**Memorandum
 Planning and Urban Development Department
 Planning Division**

To: Stuart O’Brien, Chair and Members of the Portland Planning Board
 From: Jean Fraser, Planner
 Date: May 15th, 2015
 Re: Neighborhood Center and Preschool/Daycare
 1342 Congress Street
 Site Plan and Conditional Use(s)
 Jewish Community Alliance of Southern Maine, Applicant
 Project #: 2015-058 CBL: 191 B016001
 Meeting Date: May 19th, 2015

CROSS SECTION UNDERDRAINED SOIL FILTER
DETAIL
NOT TO SCALE

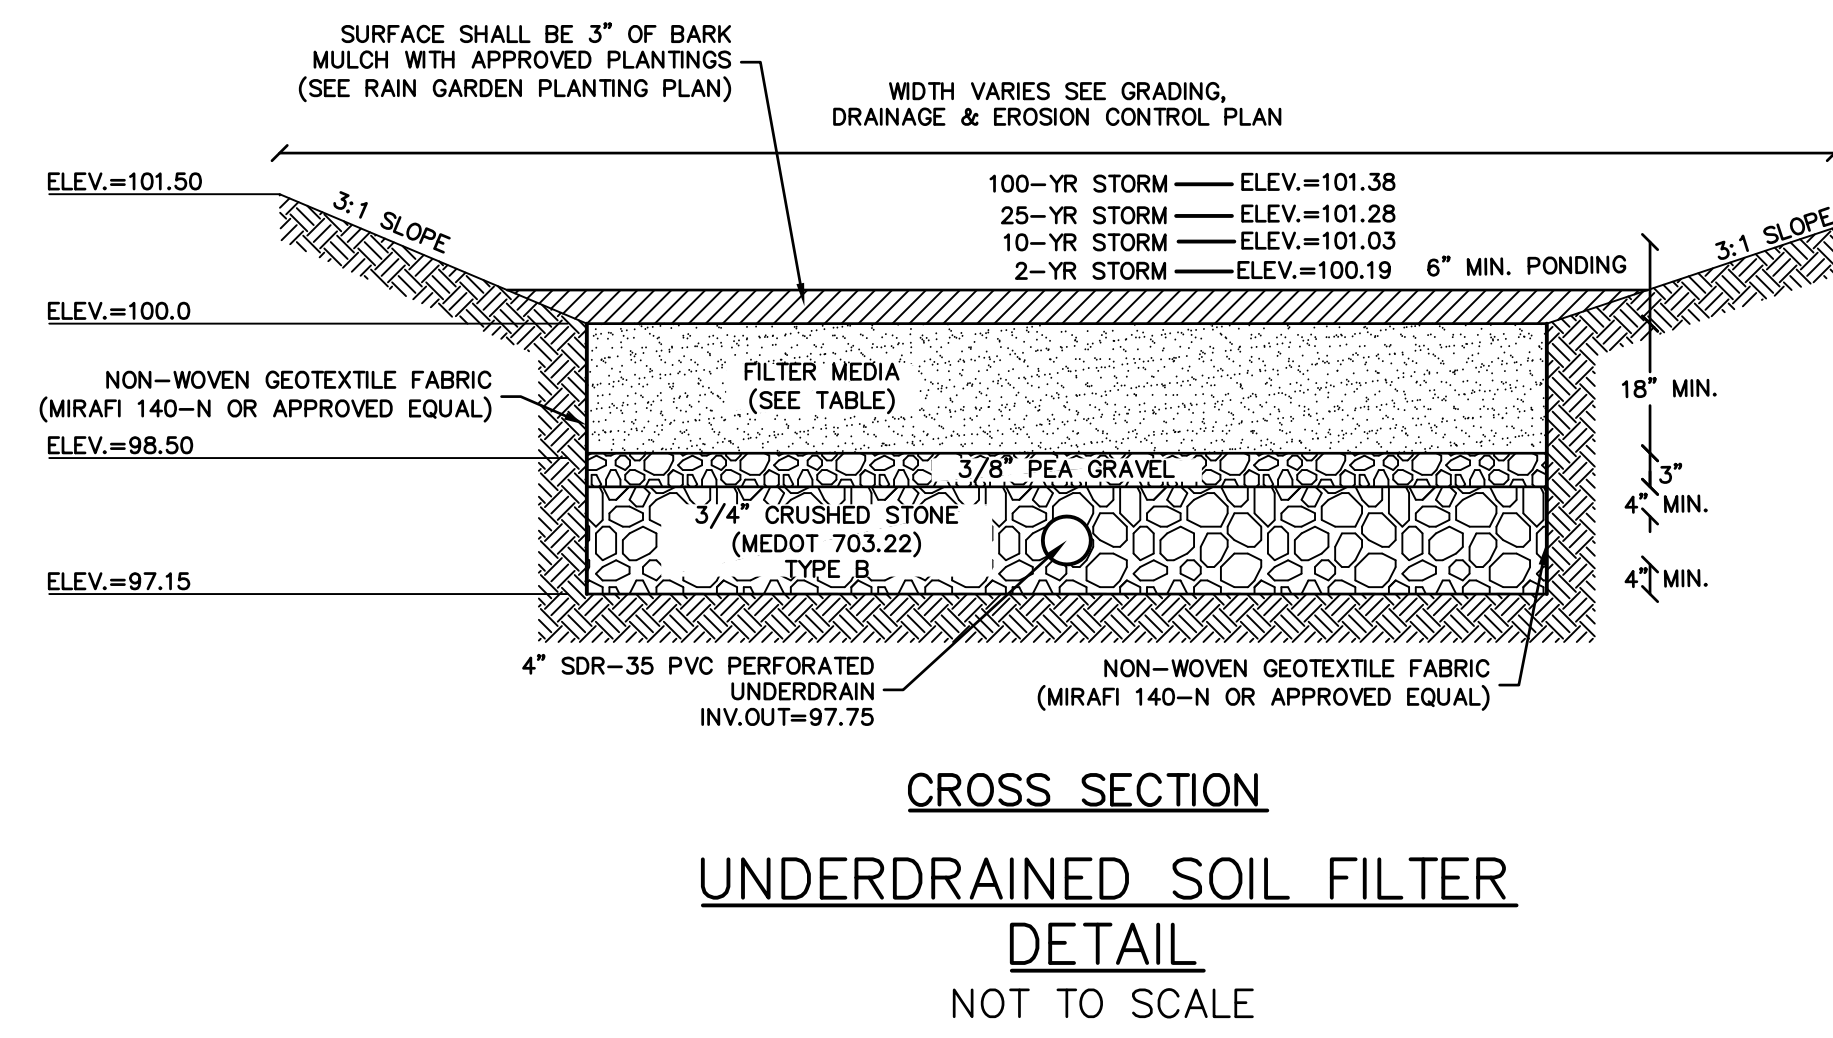
- *The proposed Underdrained Soil Filter Bed detail refers to a Rain Garden Planting Plan for proposed plantings; however, it does not appear that this plan has been provided at this time.*

Update: The Applicant has acknowledged that the Landscape Plan, Sheet L-1, will be updated to include an appropriate planting plan for the Underdrained Soil Filter with the Final Site Plan Submission.

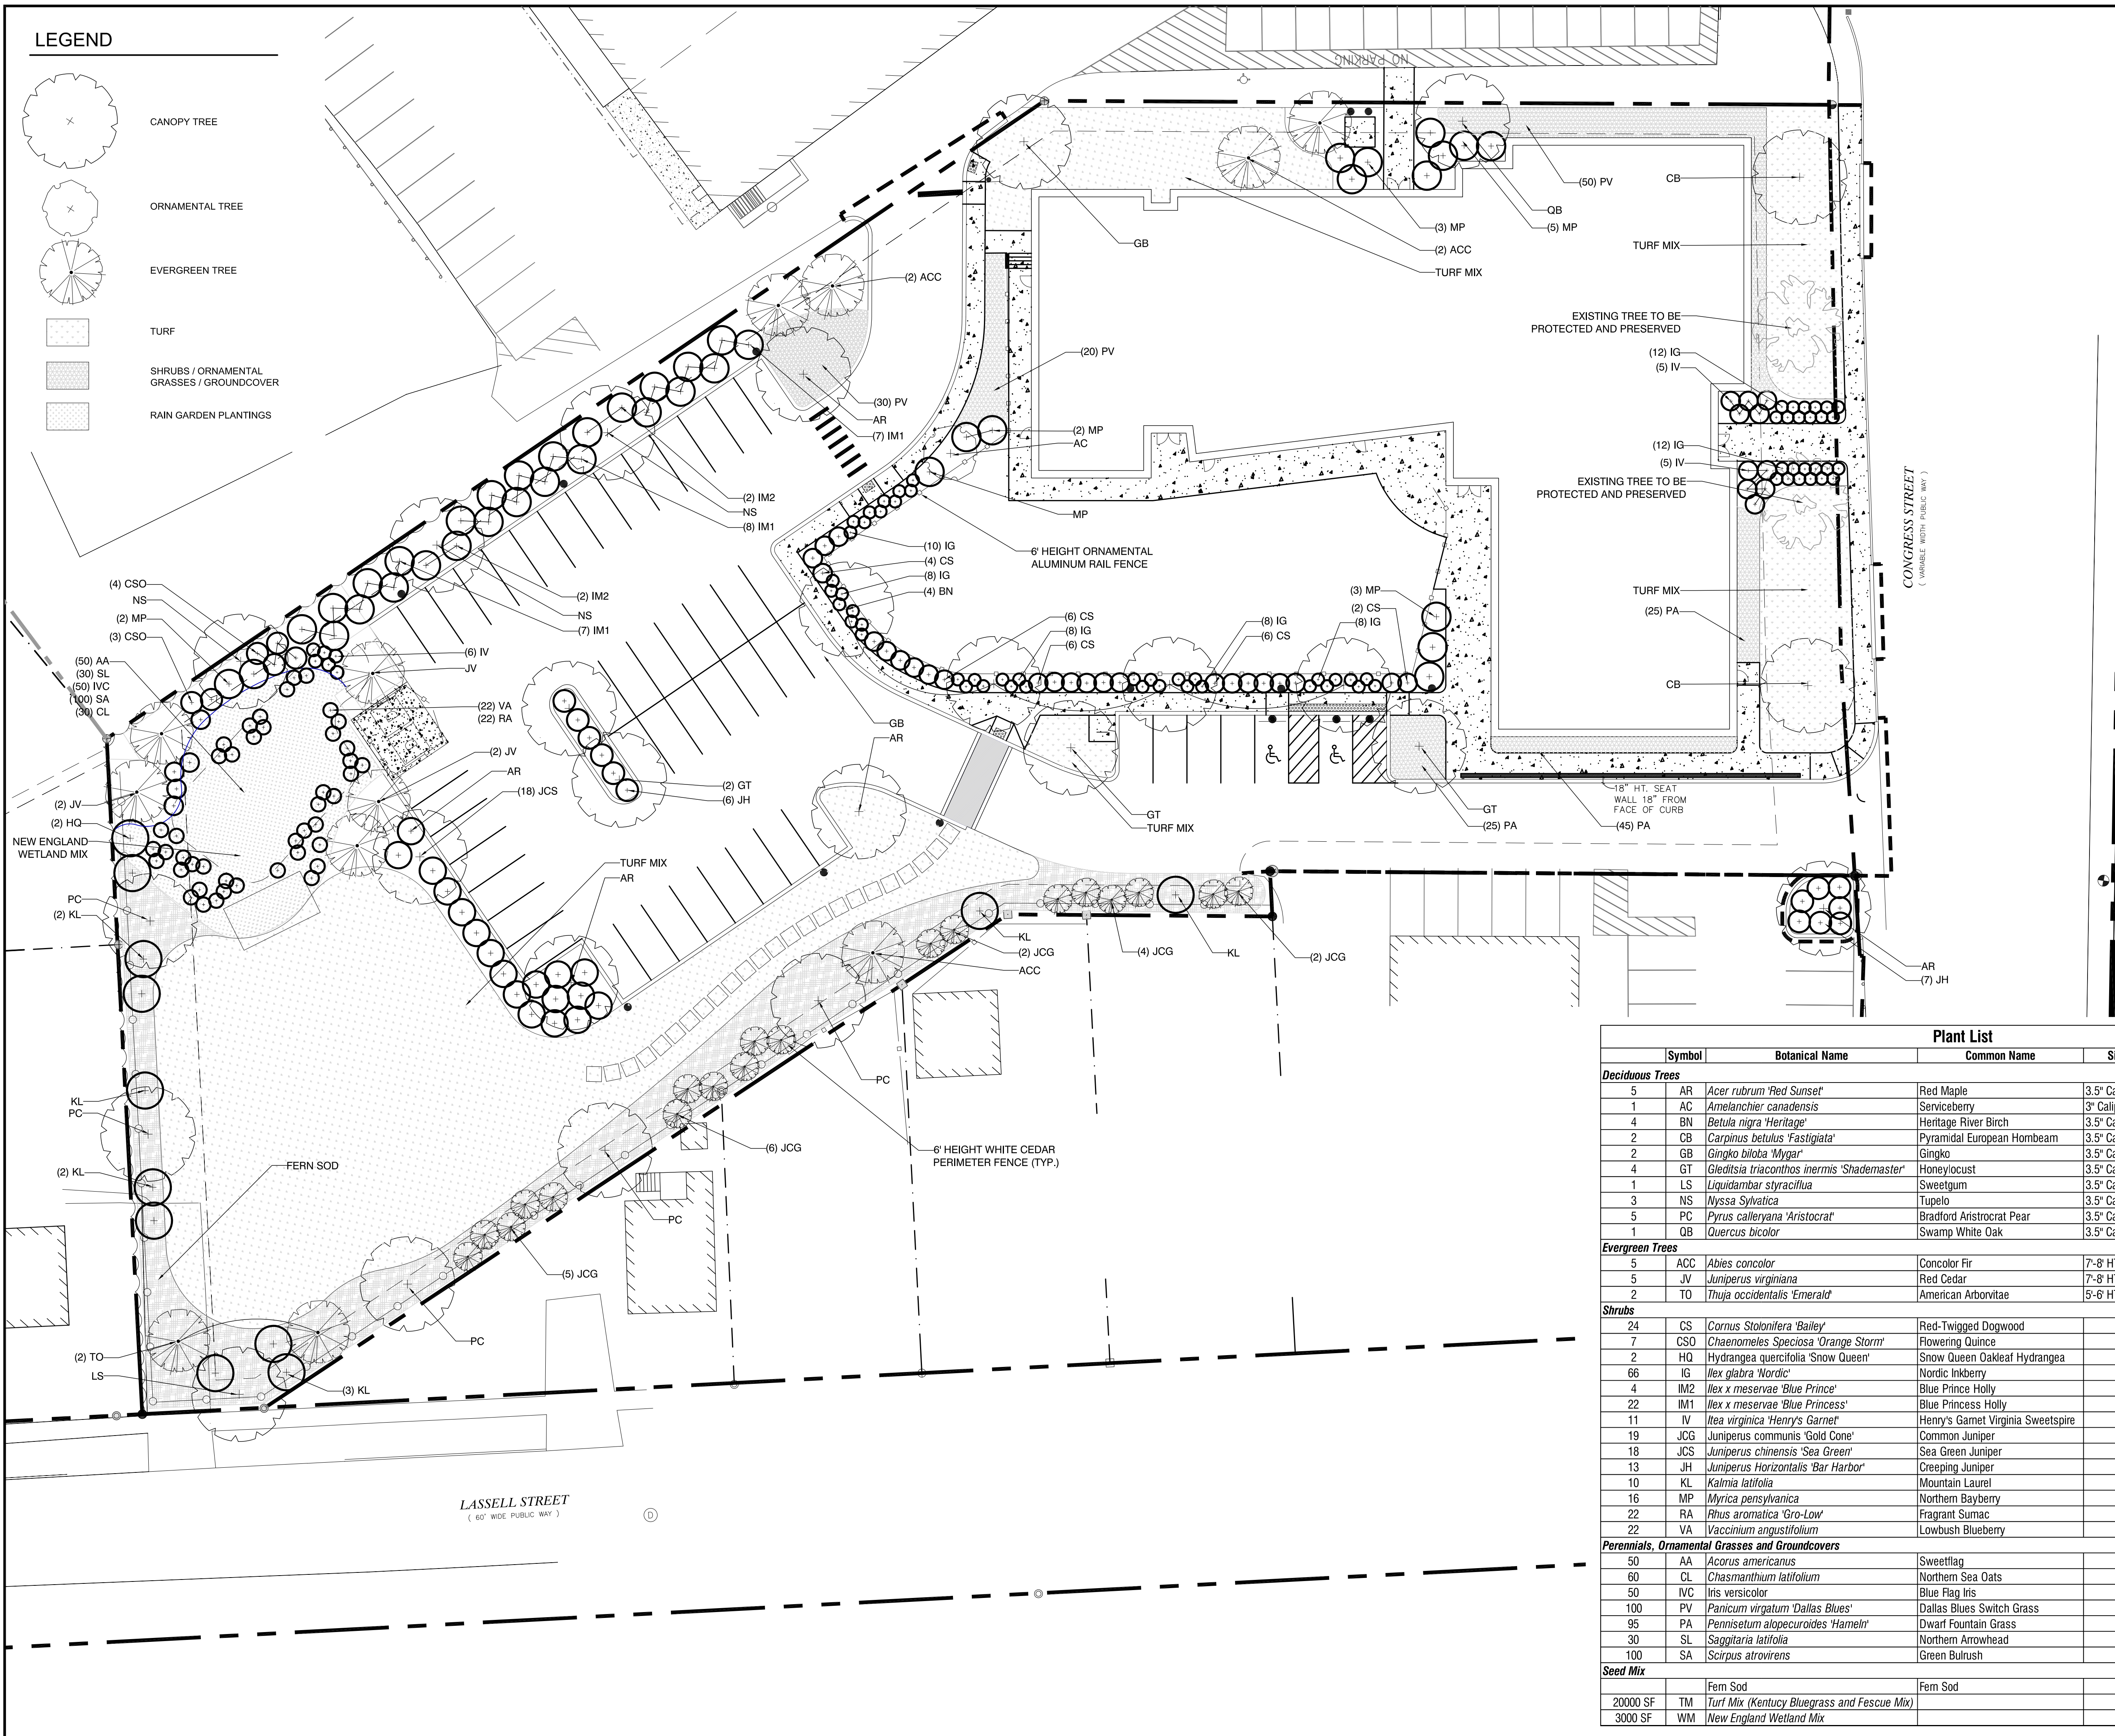
A Landscape Plan is included in Plan P10 but does not include tree planting along the side facing the dental offices where 5 large trees have been removed. It is not clear how servicing vehicles will be handled, but a fire truck turning template was submitted (Plan P8).

- *Looking at the back property line and the graphic showing a proposed fence, which is recommended, wanted to request a fence spec. My first thought is that the fence should be wooden 6' in height or something equal.*
- *The project removes several mature trees on the side entranceway and does not appear to replace them. Looking at the space it appears to be wide enough that several, 3 - 4 small trees such as Magnolia, Dogwood or Cherry could be successfully planted back in this location. We have also seen good use of the several upright Oak varieties that stay very narrow but with height that could help replace the lost trees. Improving this space should be a priority. See: <http://www.jfschmidt.com/pdfs/regalprinceoak.pdf>.*
- *Also noted that a small center landscaped island near the entranceway could be used to improve or define the drive into the site.*
